Prepared for:
NSW Department of Education

Date:
14 January 2022

Response to Submissions Report (SSD-23330227)

John Palmer Public School

Title
LANDSCAPE PLAN

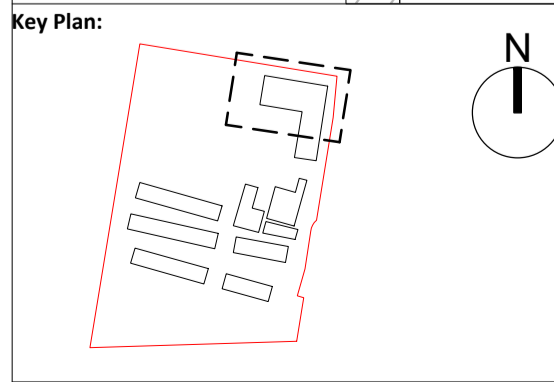
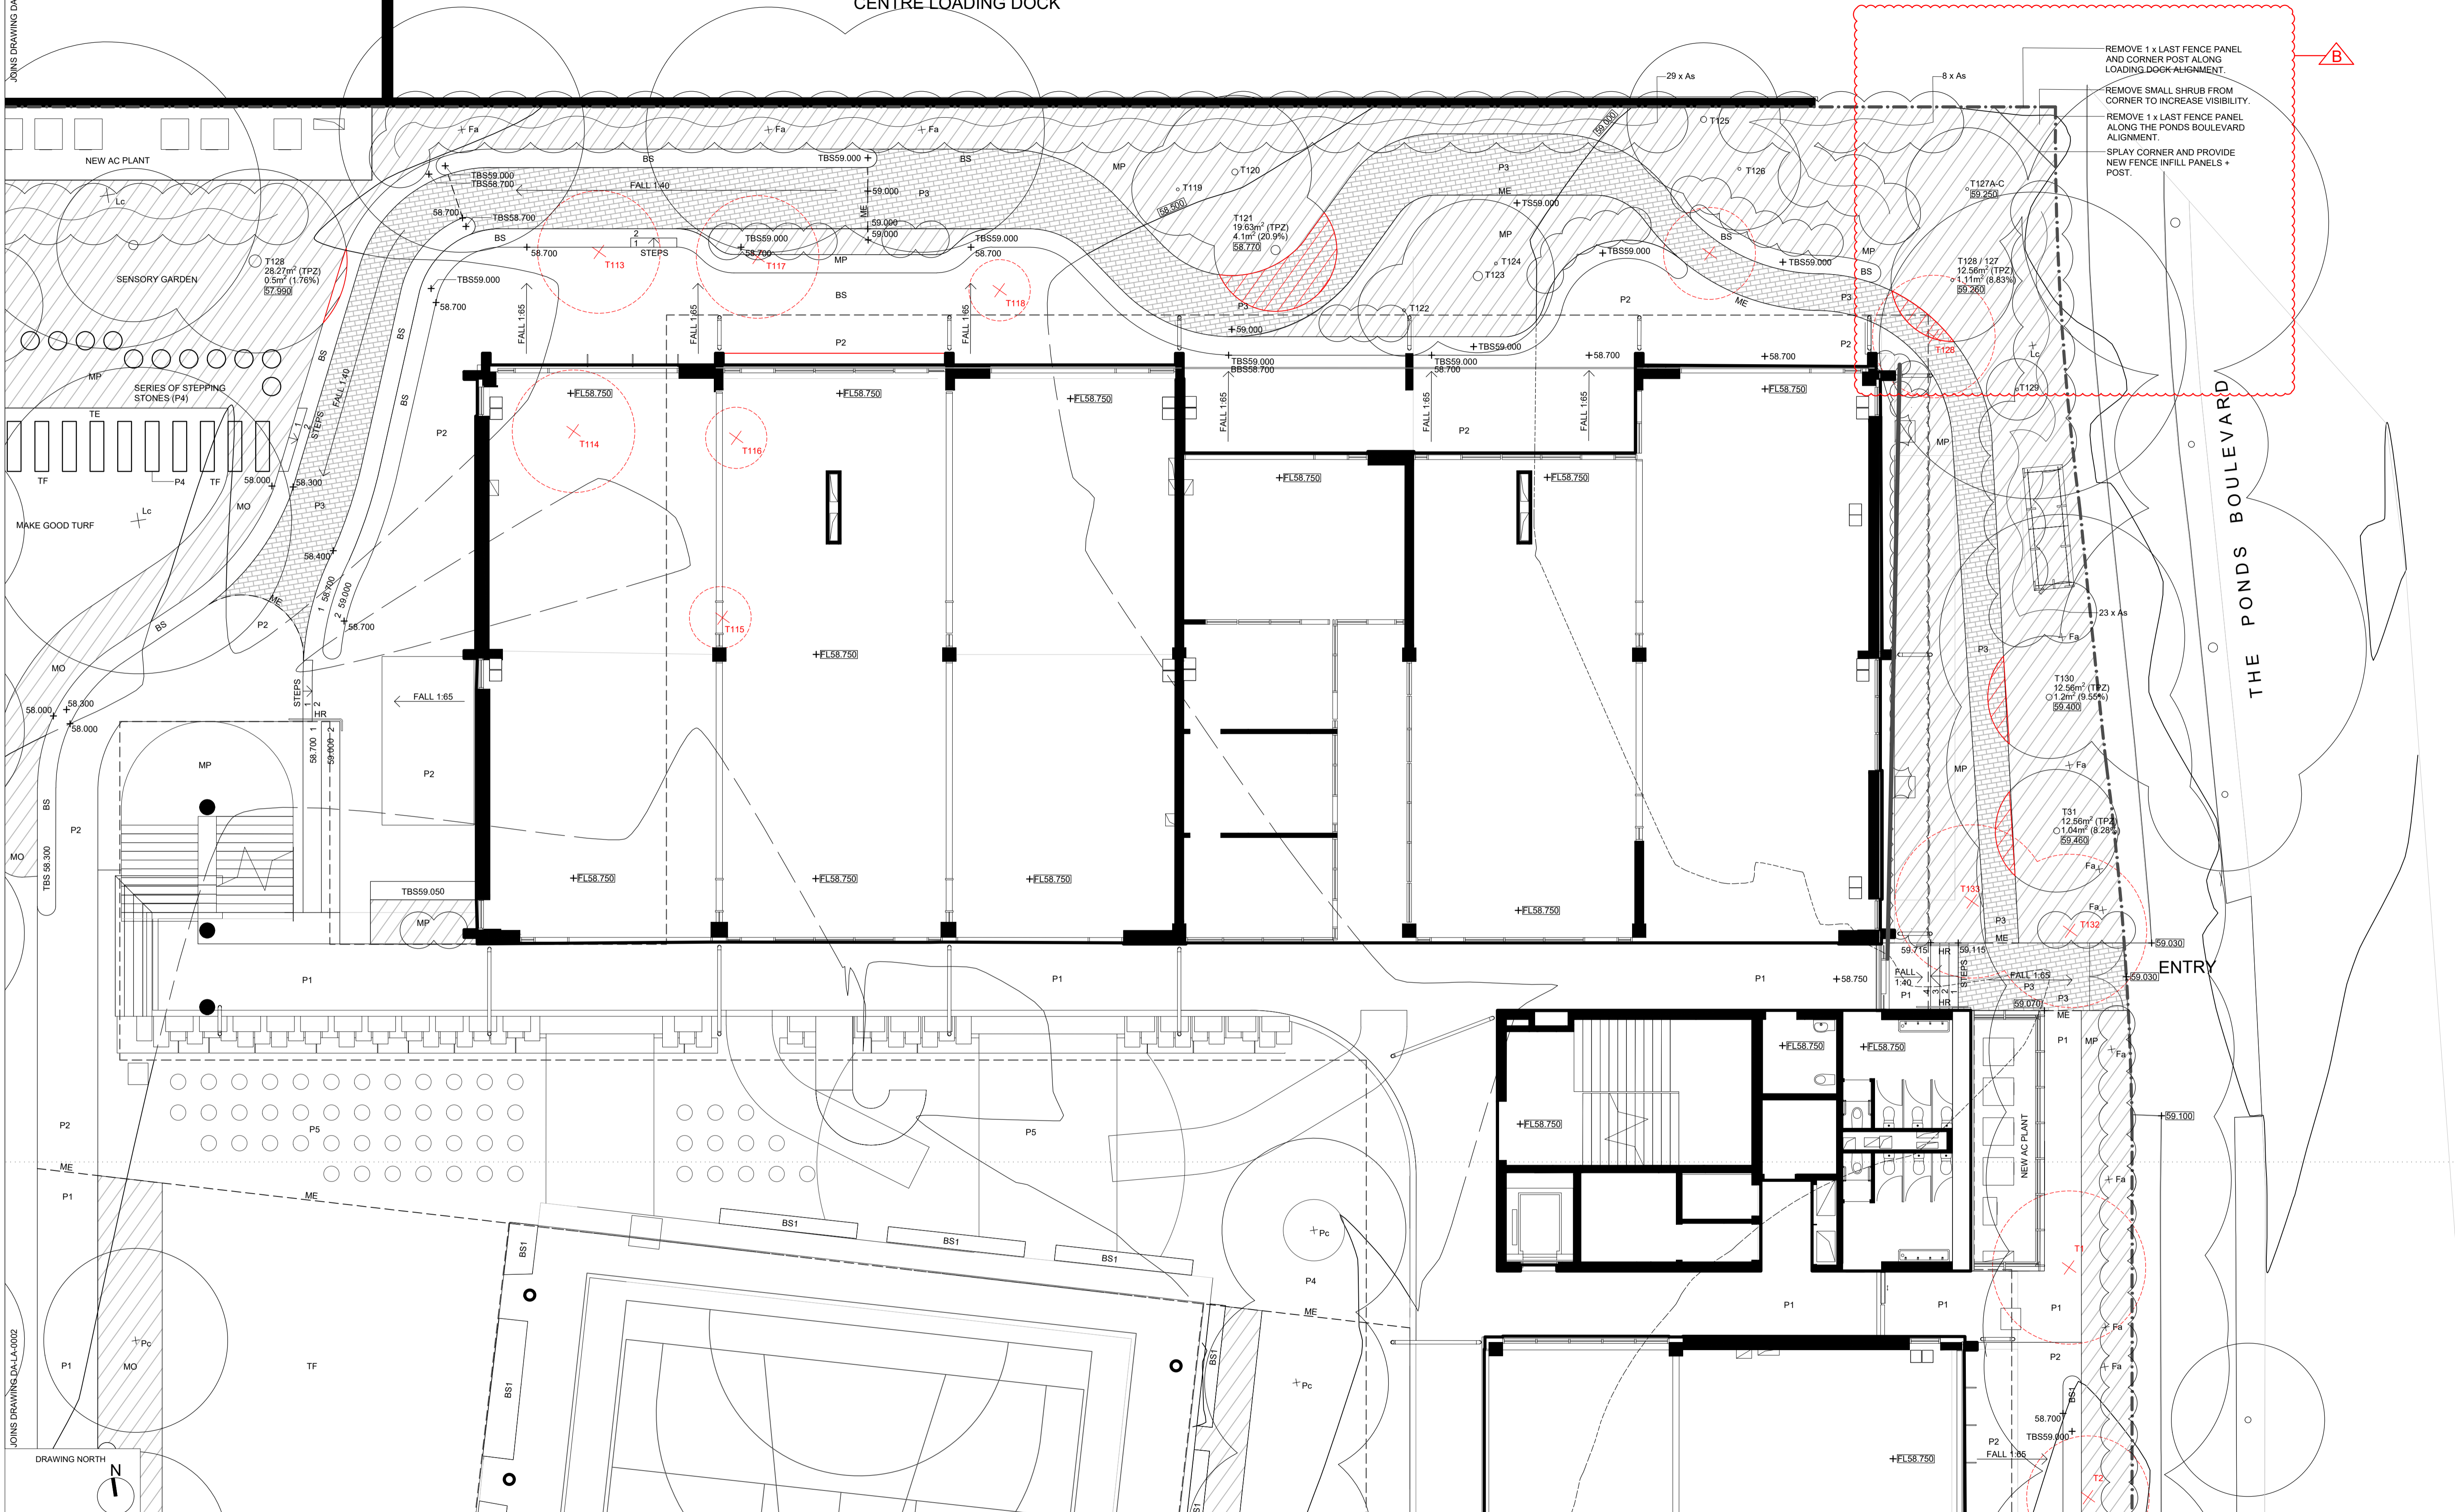
- **Pedestrian Safety** – Blacktown City Council have also raised concern regarding safety of pedestrians crossing the driveway of TPSC to the north of the site and recommend a splayed corner to improve pedestrian sightlines. Refer to **Figure 2** which illustrates the relationship of the fence adjacent to TPSC.

Drawing Number
DA-LA-0005

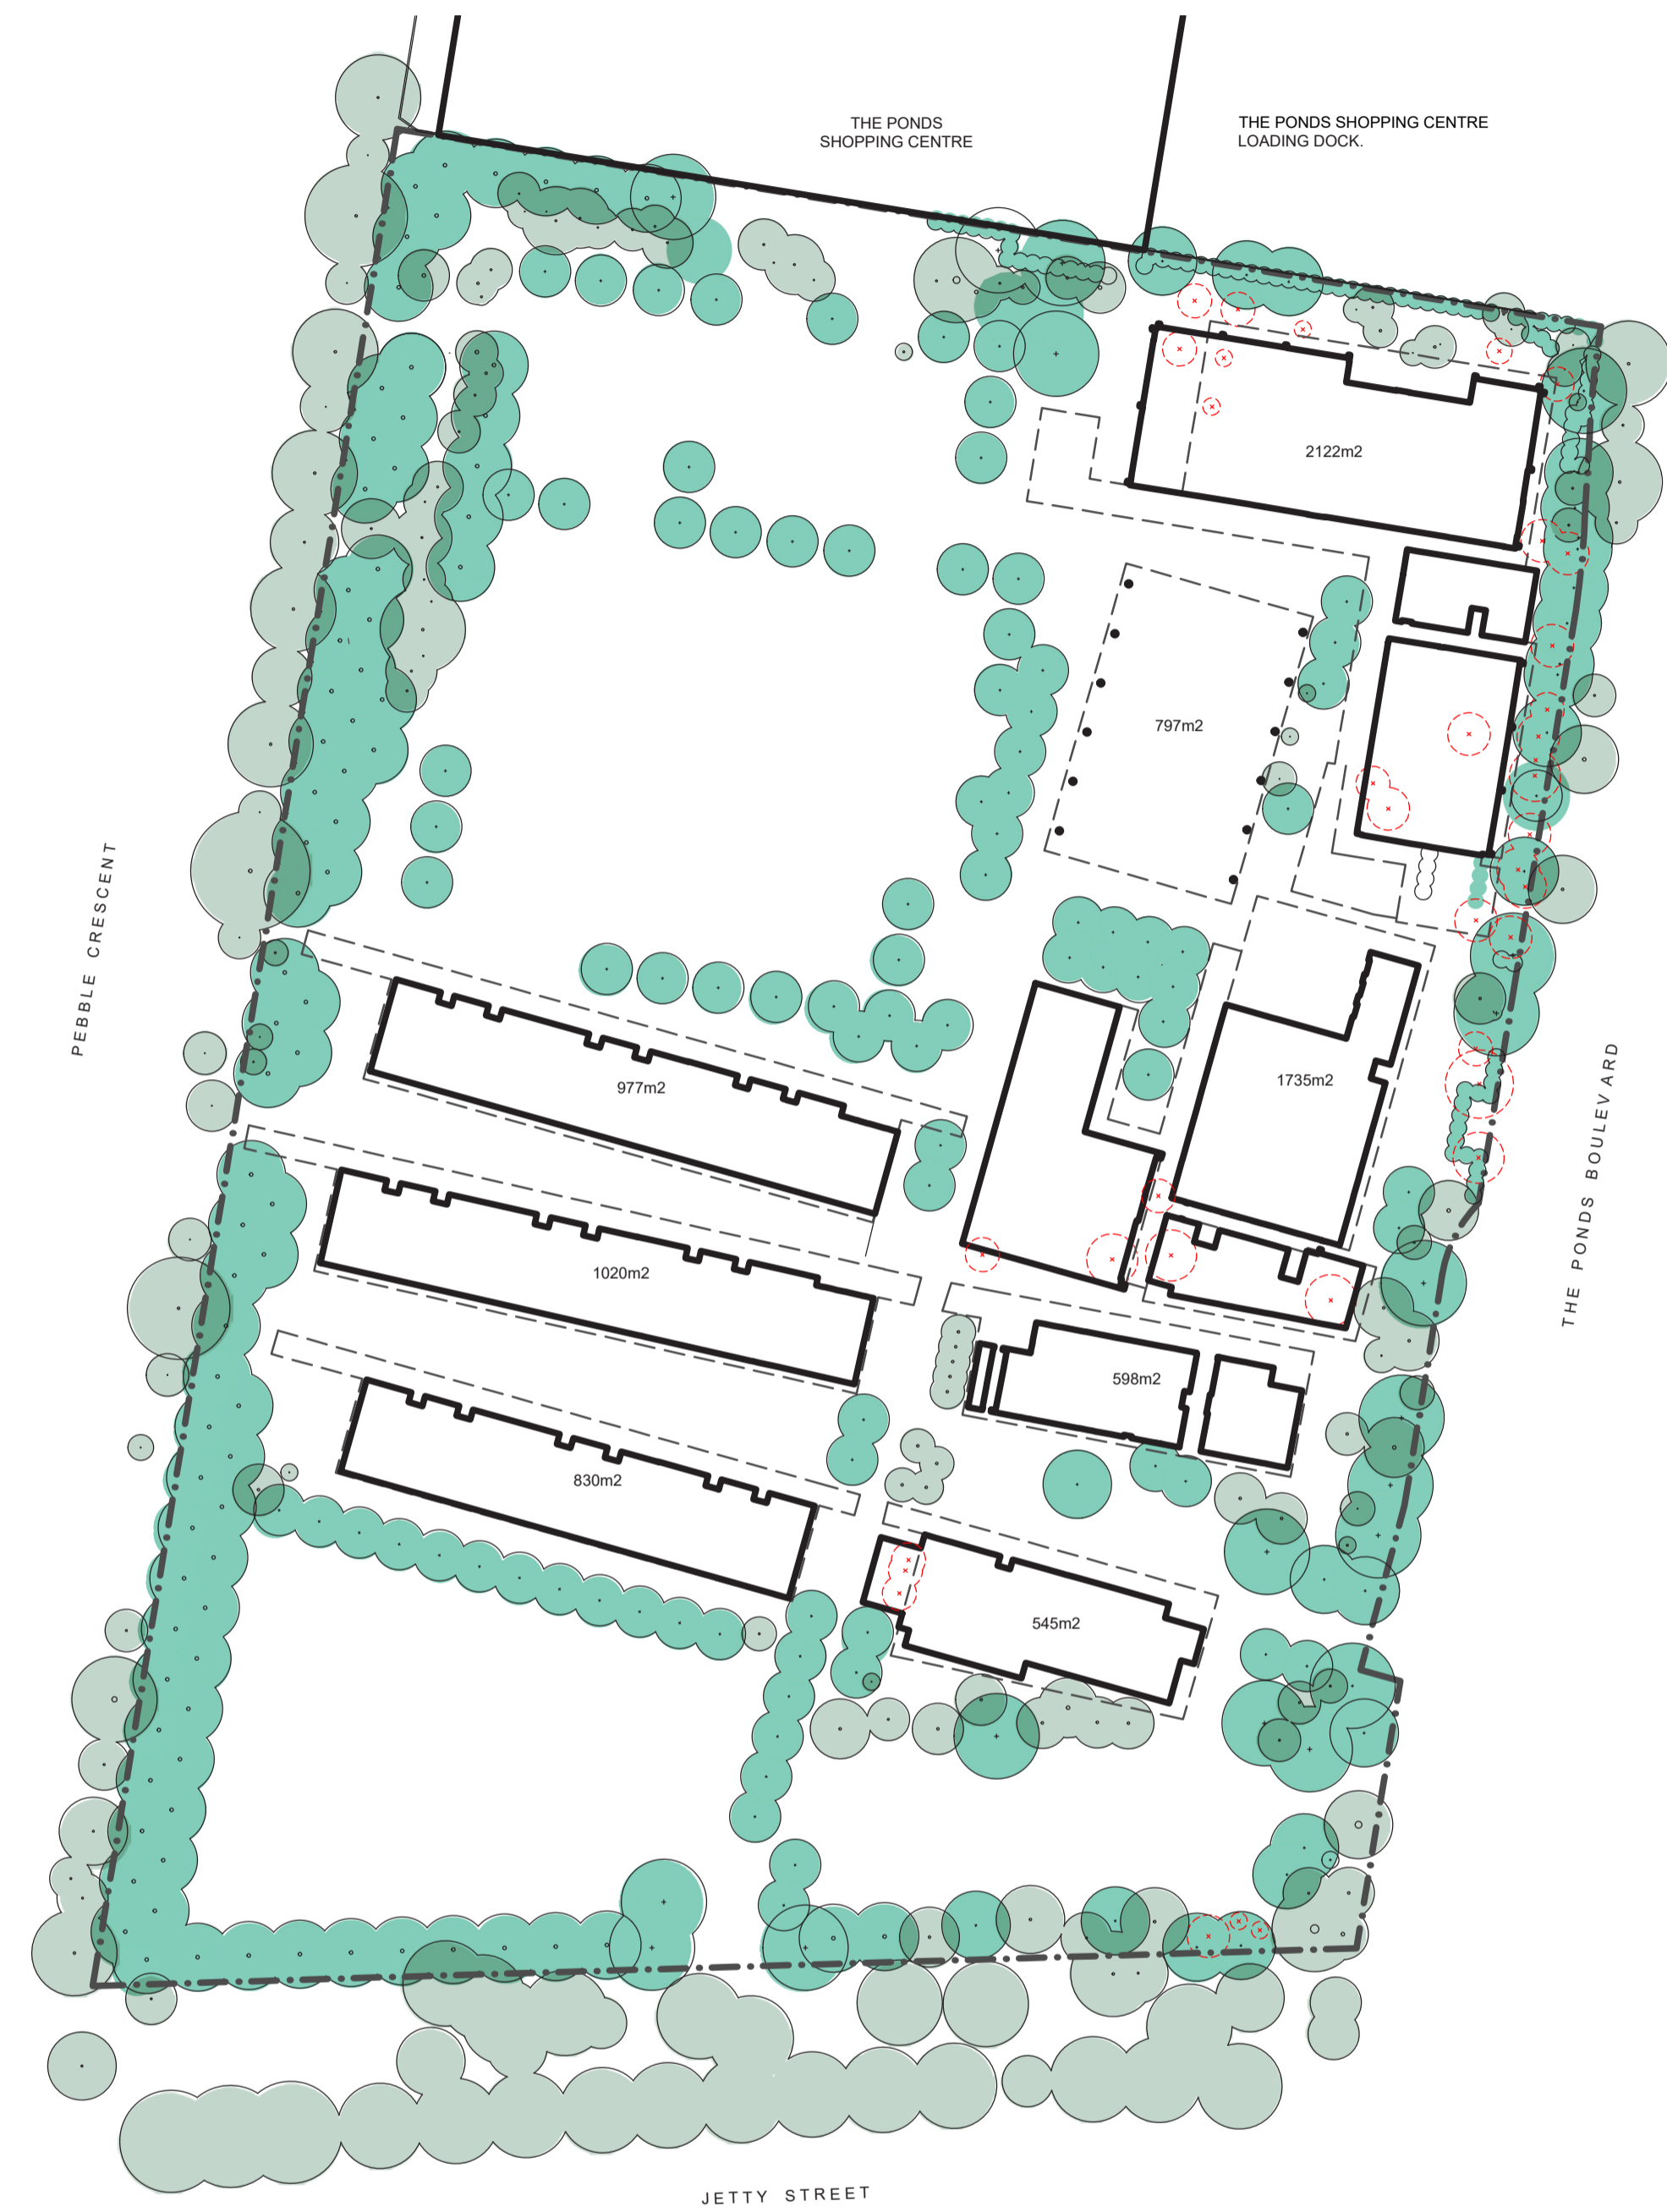
Furthermore, it is noted that Endeavour Energy have provided a submission which raises concerns regarding the proximity of screen planting around the padmount substation along The Ponds Boulevard frontage.
